**Petitioner is requesting indefinite continuation of this petition since his agent is recovering from surgery.**

<b>REQUEST</b>	Current Zoning: R-3, single family residential Proposed Zoning: UR-3(CD), urban residential, conditional
<b>LOCATION</b>	Approximately 1.0 acre located on the east side of Park Road, north of Sharon Road.
<b>CENTER, CORRIDOR OR WEDGE</b>	Wedge
<b>SUMMARY OF PETITION</b>	This is a continuation of a public hearing that was opened on November 17, 2008. The petitioner is requesting an indefinite deferral of this petition to allow his agent to recover from surgery and make the presentation at the public hearing. This petition proposes a 12-unit multi-family building that is up to 60 feet (five stories) in height. The building is an environmentally innovative structure that maximizes solar energy principles.
<b>STAFF RECOMMENDATION</b>	Staff recognizes the innovative “green” nature of this development and that the proposal is consistent with adopted land use plans and policies. However, the 60-foot height and the architecture associated with the project are concerns that keep the staff from supporting the project as currently proposed. Hopefully, these issues

1-1 SCHEMATIC SITE PLAN
Z1 SCALE: 1" = 50'-0"

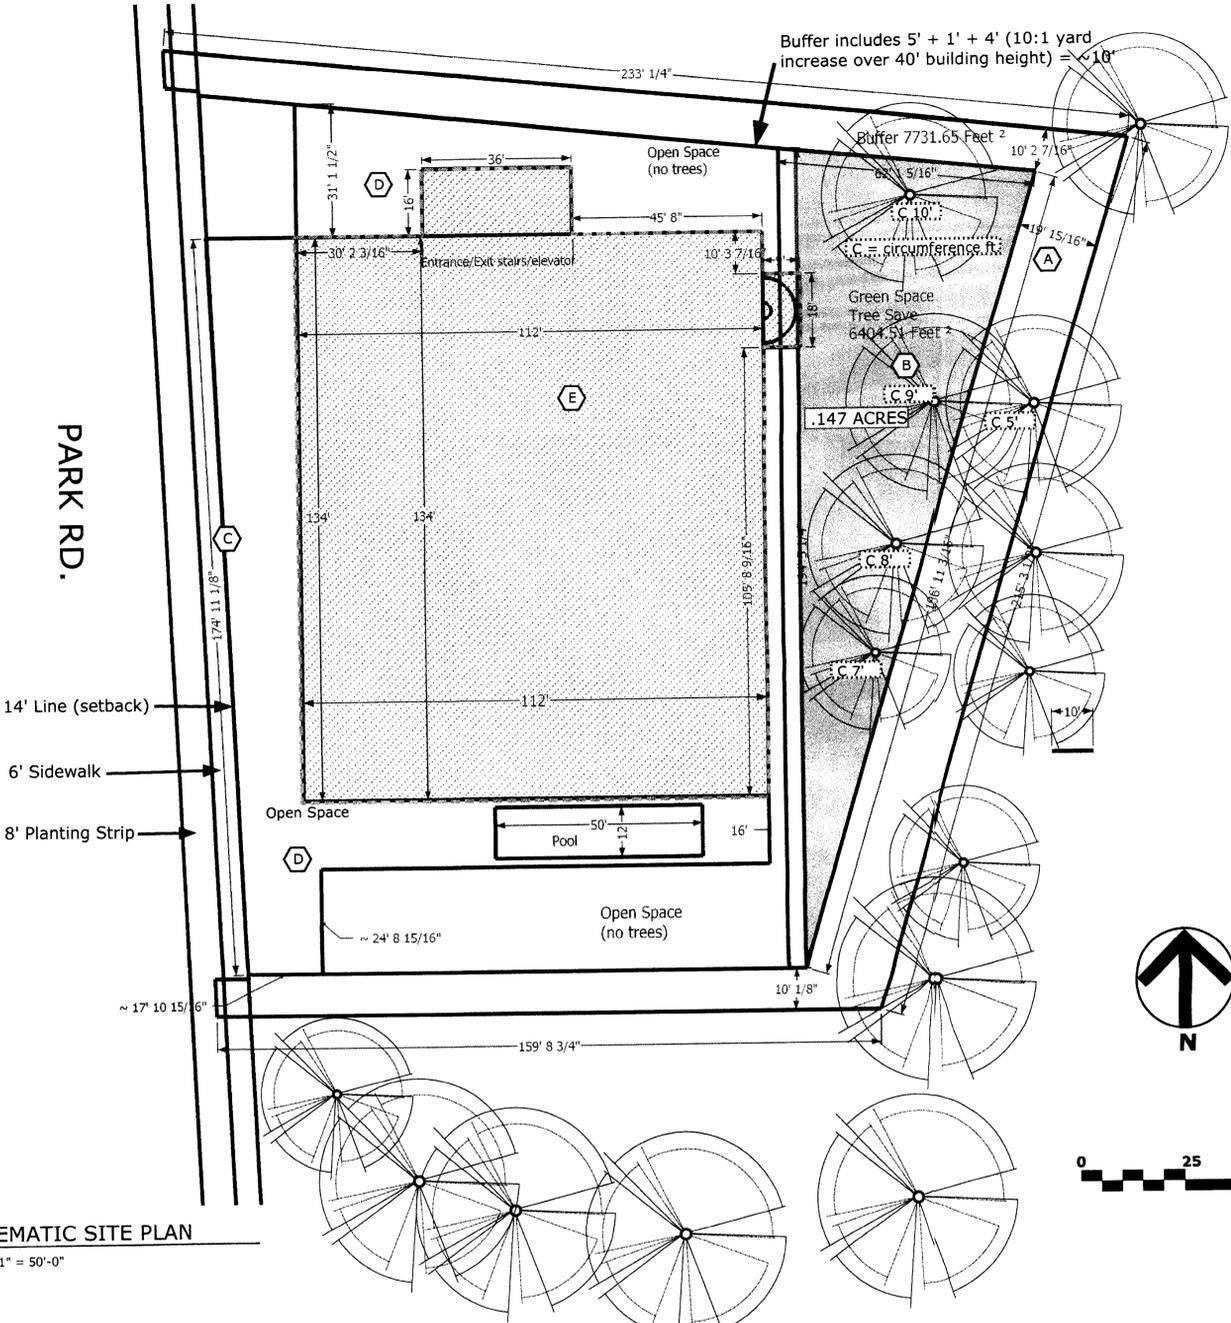
3. The petitioner should provide more details (height, slope, materials, etc.) regarding the privacy/noise barrier along Park Road.
  4. The building is shown as 45,000 square feet of gross floor area. This means the average unit size is 3,750 square feet. These large units appear to contribute to the size of the building and should be re-examined.

8. The petitioner should add a note that additional right-of-way will be dedicated and conveyed to provide 50 feet from the centerline of Park Road. In addition, the site plan needs to show the proposed curb being four feet outside the existing curb.

10. The petitioner should add a note explaining how trash collection will be accomplished.
  11. While tree save and open spaces are shown, the petitioner should provide more details on what they consist of and which trees will be saved. For trees likely to be impacted by the development, the petitioner should add a note that a tree preservation plan will be undertaken by a certified arborist.

1 FRONT ELEVATION (WEST)
Z2 SCALE: 1" = 40'-0"

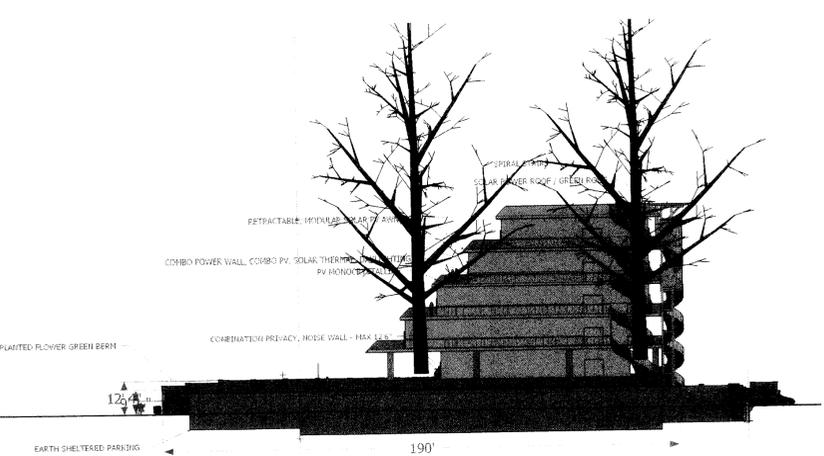
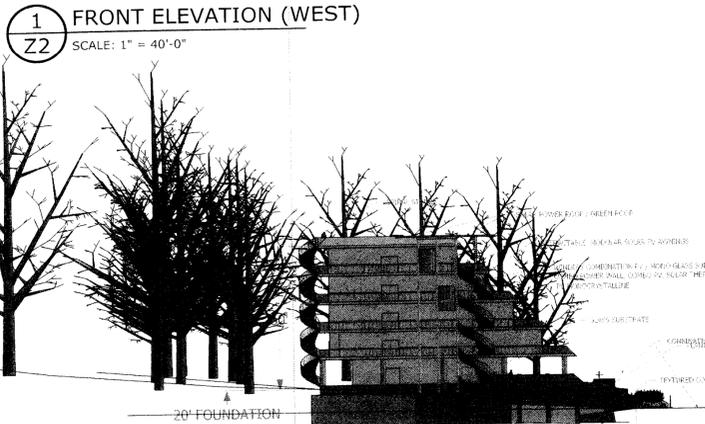
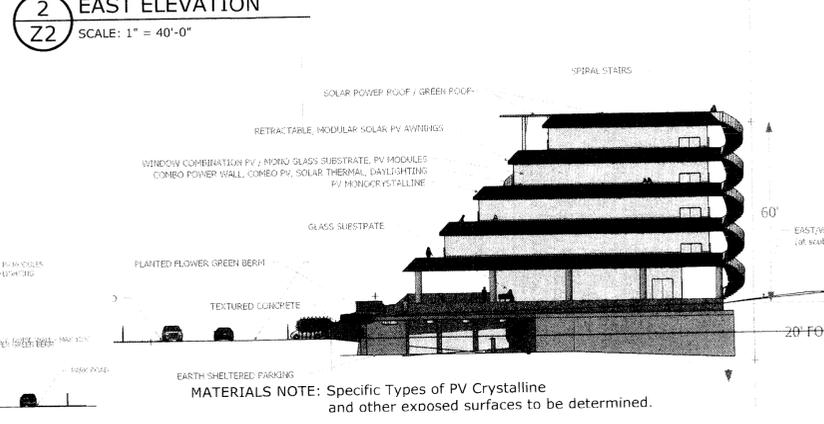
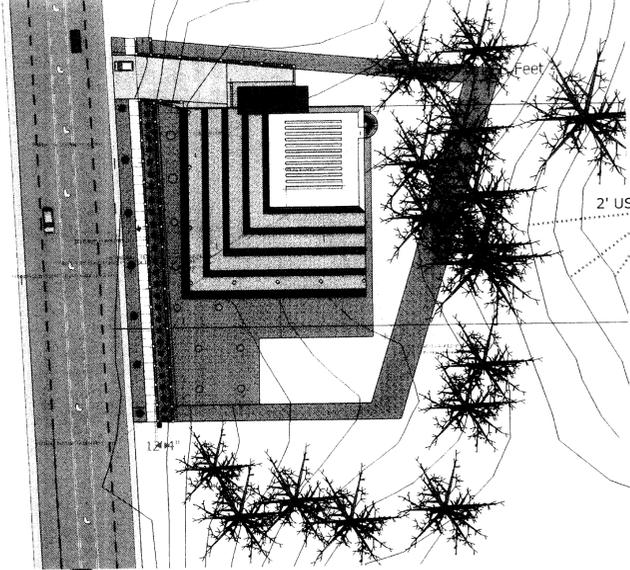
5. The petitioner should provide an explanation for "solar power roof/green roof" in the site plan notes
  6. The petitioner should remove the note allowing the height of the building to exceed 60 feet.

7. The petitioner should add a note to the site plan providing a standard of reflectivity/glare that will not be exceeded. This should apply not only to neighboring properties but to motorists.
